NSIP Reference Name / Code: A46 Coventry Junctions (Walsgrave) / TR010066

Natural England's response to the submissions at deadline 3

Examining Authority's submission deadline 4 with a date of 22 July 2025

HE604820-OIL-EBD-00-DR-LB-30062

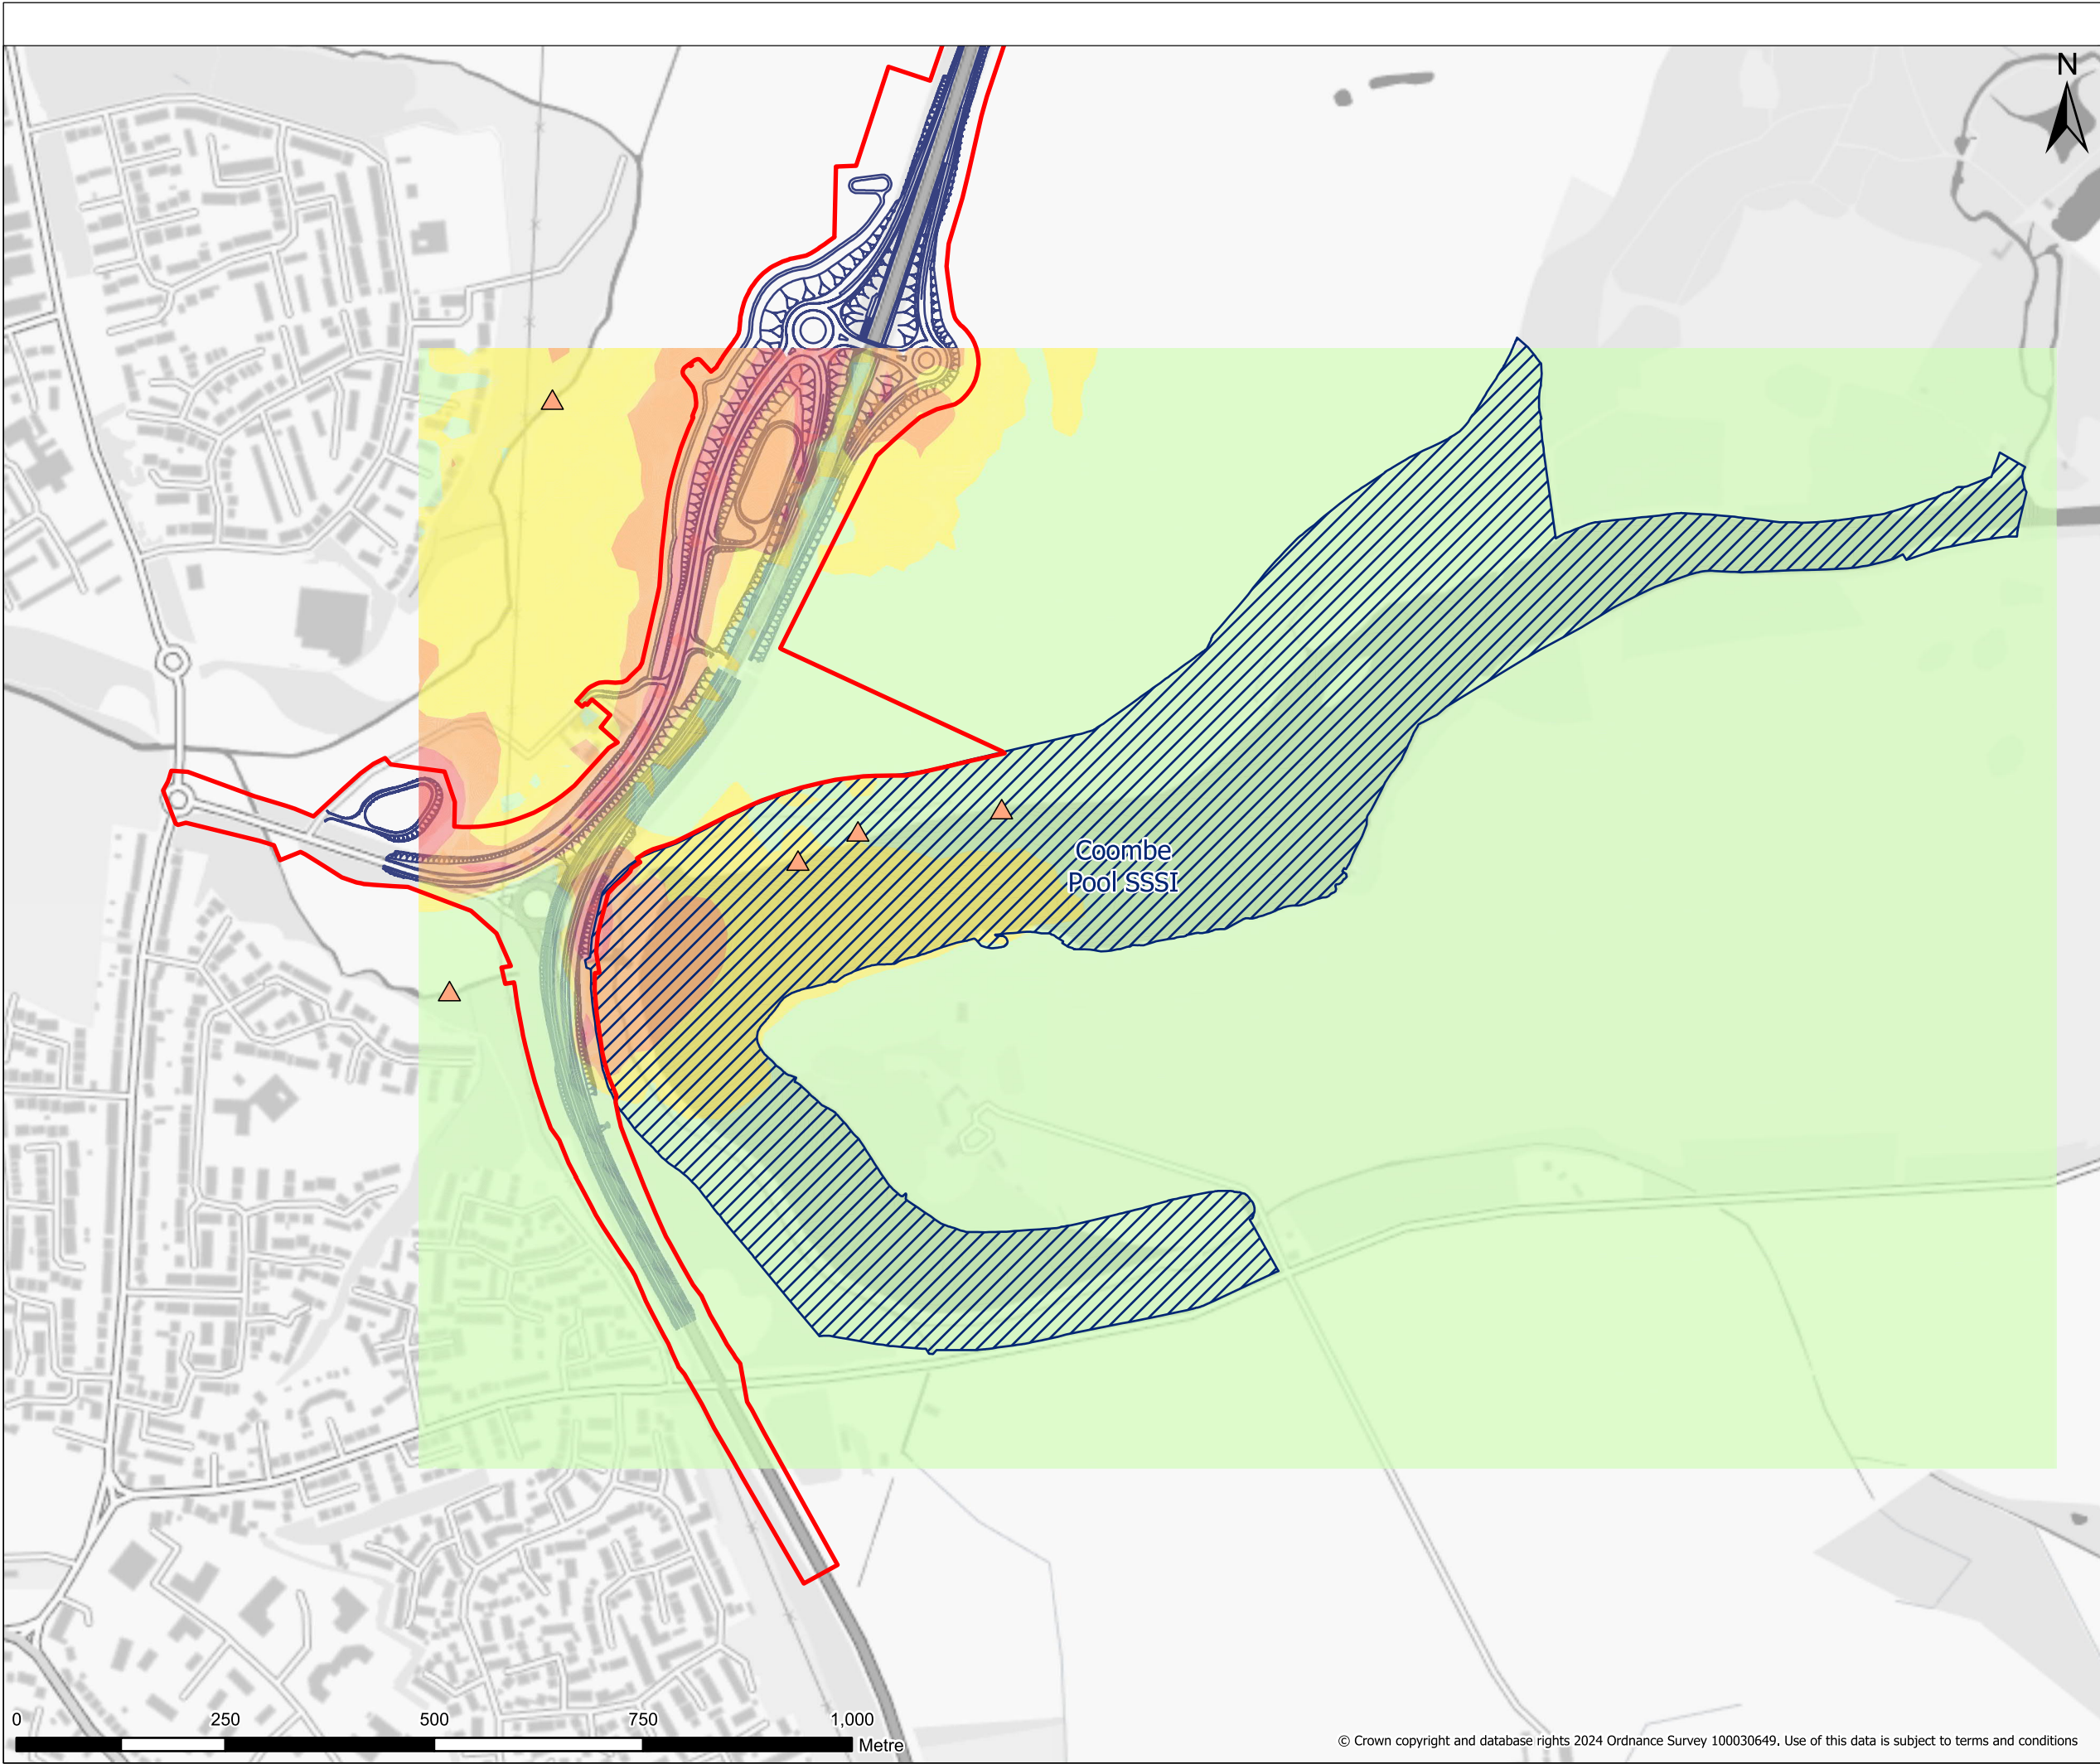
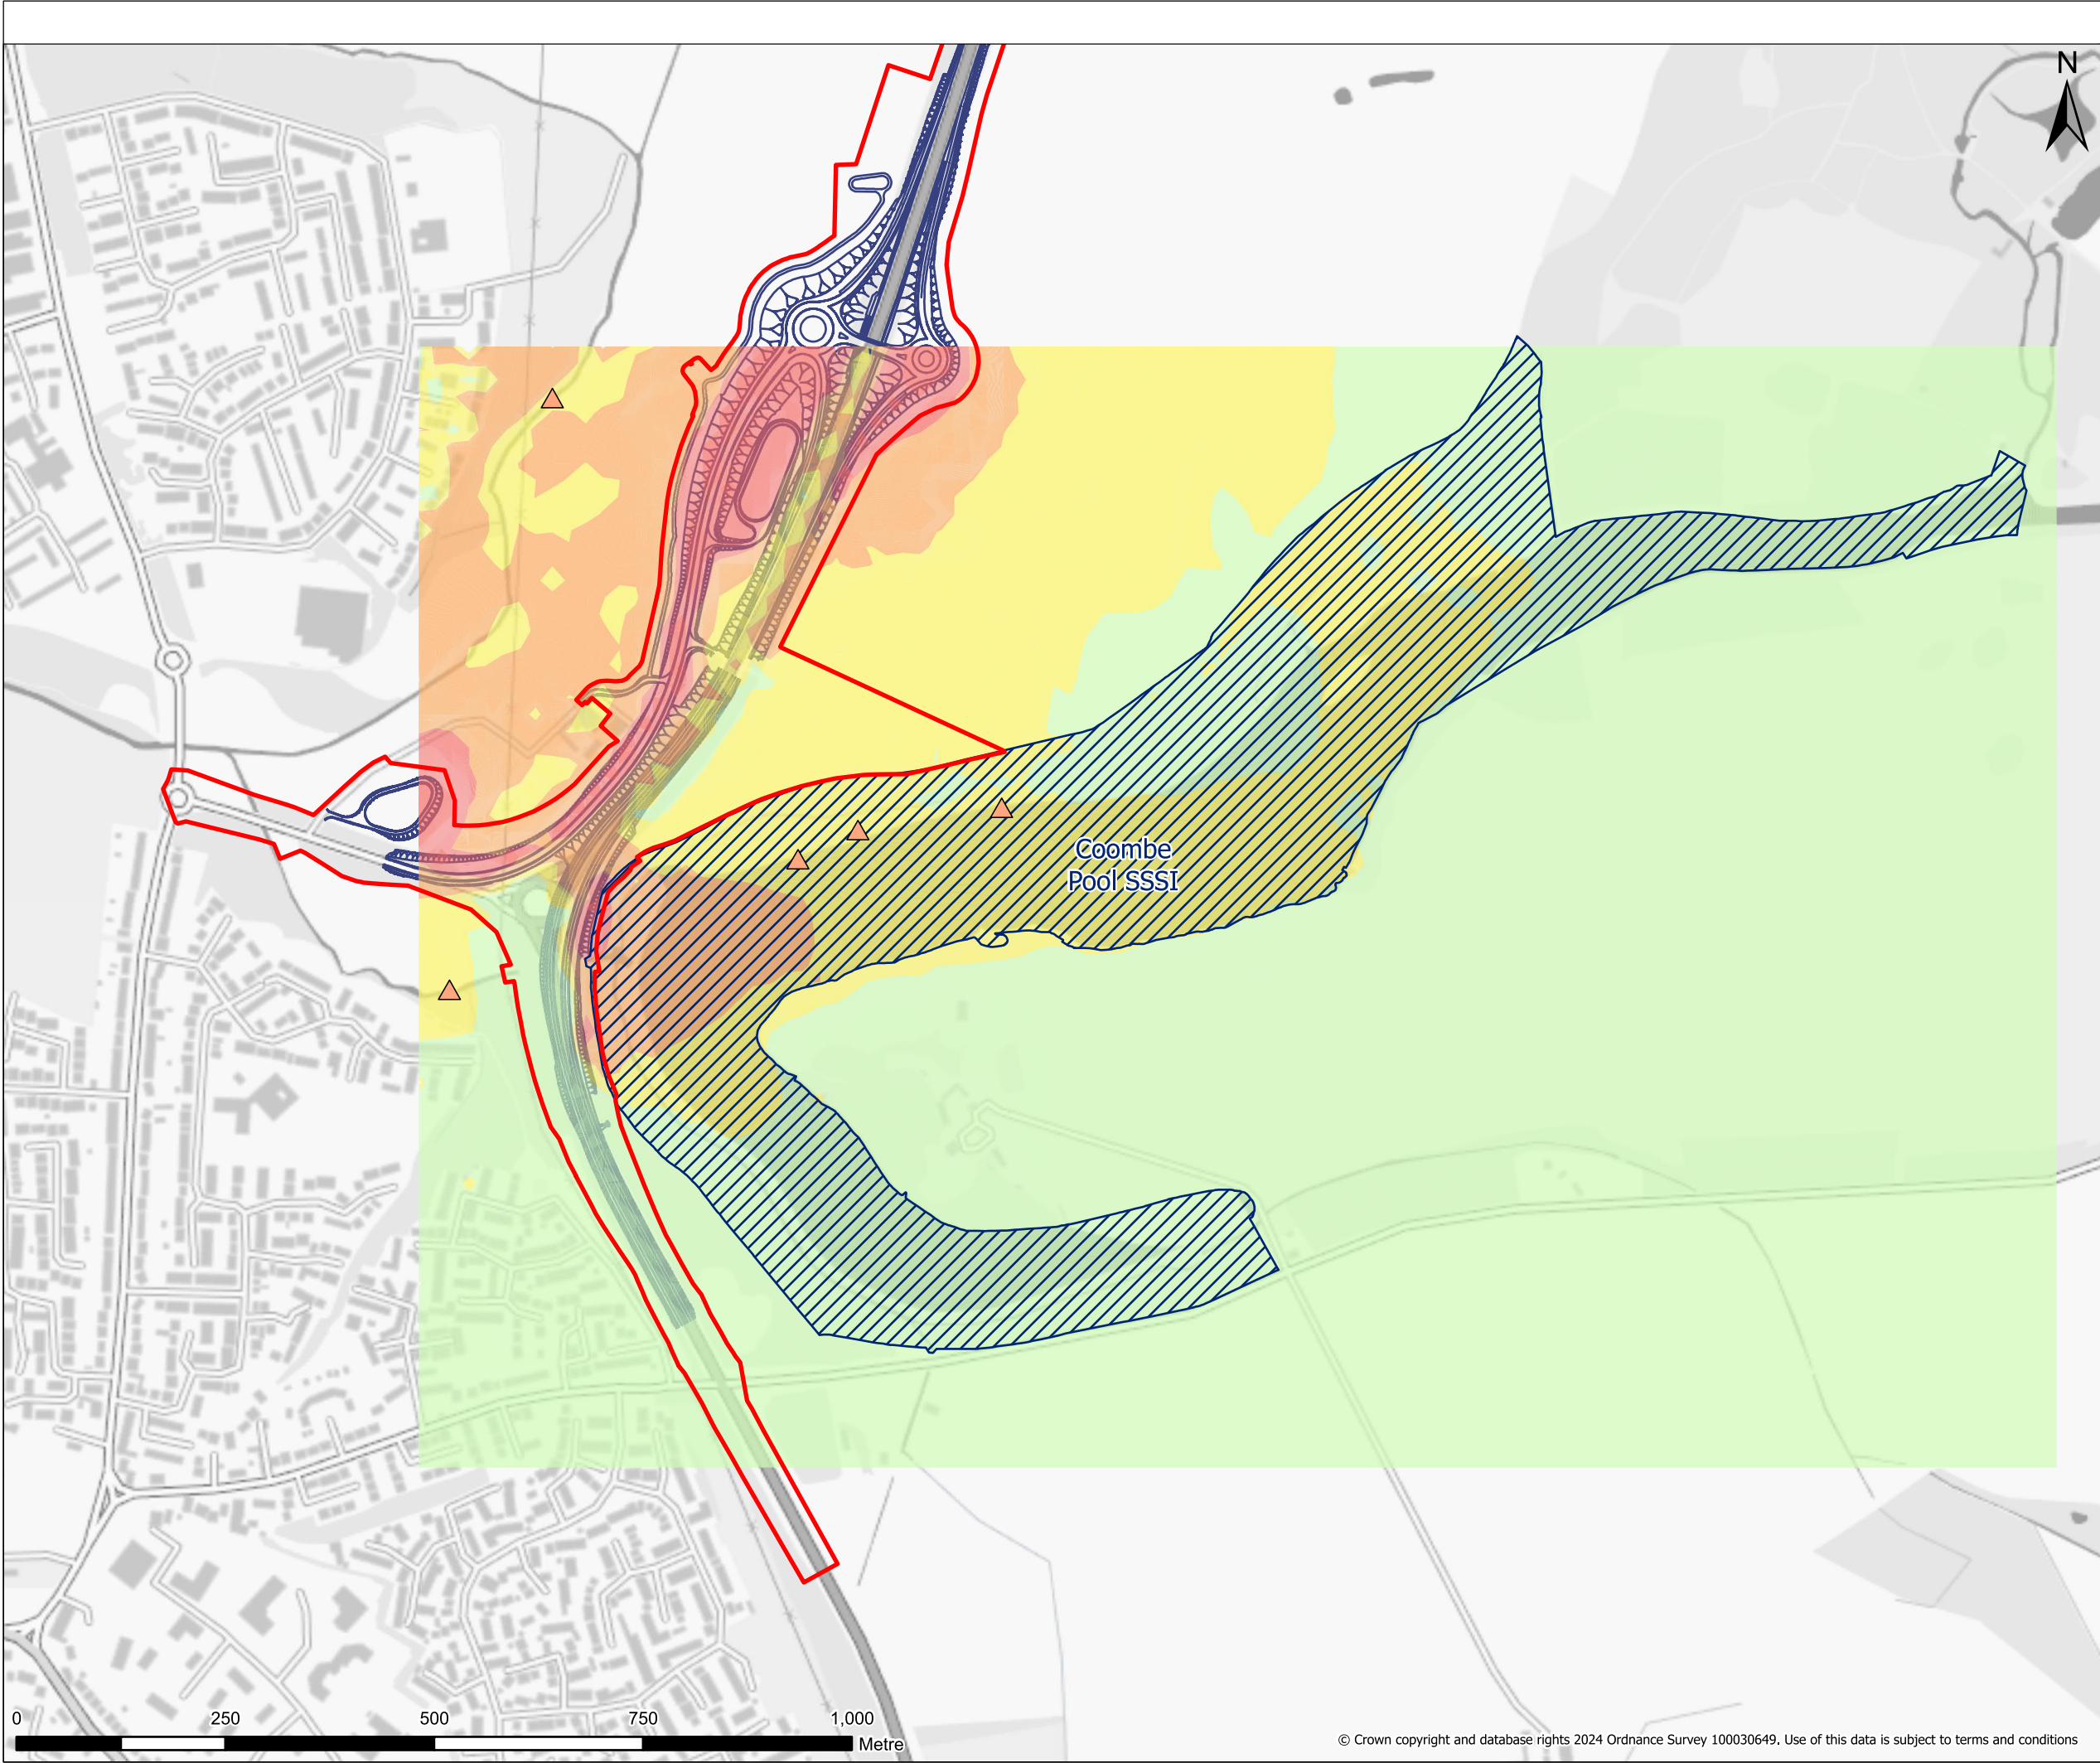
The latest submissions have provided some further information on the noise impacts. Construction noise will result in noise levels above 3dB even with a 2m noise barrier (see Table 1 below) which will impact on breeding waterbirds, wintering waterbirds (including Shoveler) and woodland breeding and wintering within Combe Pool SSSI. There will be an increase in noise levels above 3dB for a portion of the SSSI and a decrease of -1.0dB or less during operation. The modelled background noise levels at the closest edge of the lake to the Order boundary in the do minimum scenario for 2028 will be 61.5dB and 64dB for 2028 if the scheme goes ahead.

From the information provided it appears that the construction noise impacts will not be fully mitigated, and a residual impact remains. We therefore advise that the proposal should include the provision of a permanent noise barrier to mitigate for residual operational noise impacts on breeding and wintering birds.

Traffic is predicted to continue to increase over time (Source: [National road traffic projections 2022](#)) and it is likely that noise levels within the SSSI will also continue to increase for the operational stage of this road scheme. Low woodland breeding and wintering bird numbers have already been identified, which the Applicant partly attributes to the proximity of the existing road (2.1.24 REP3-028).
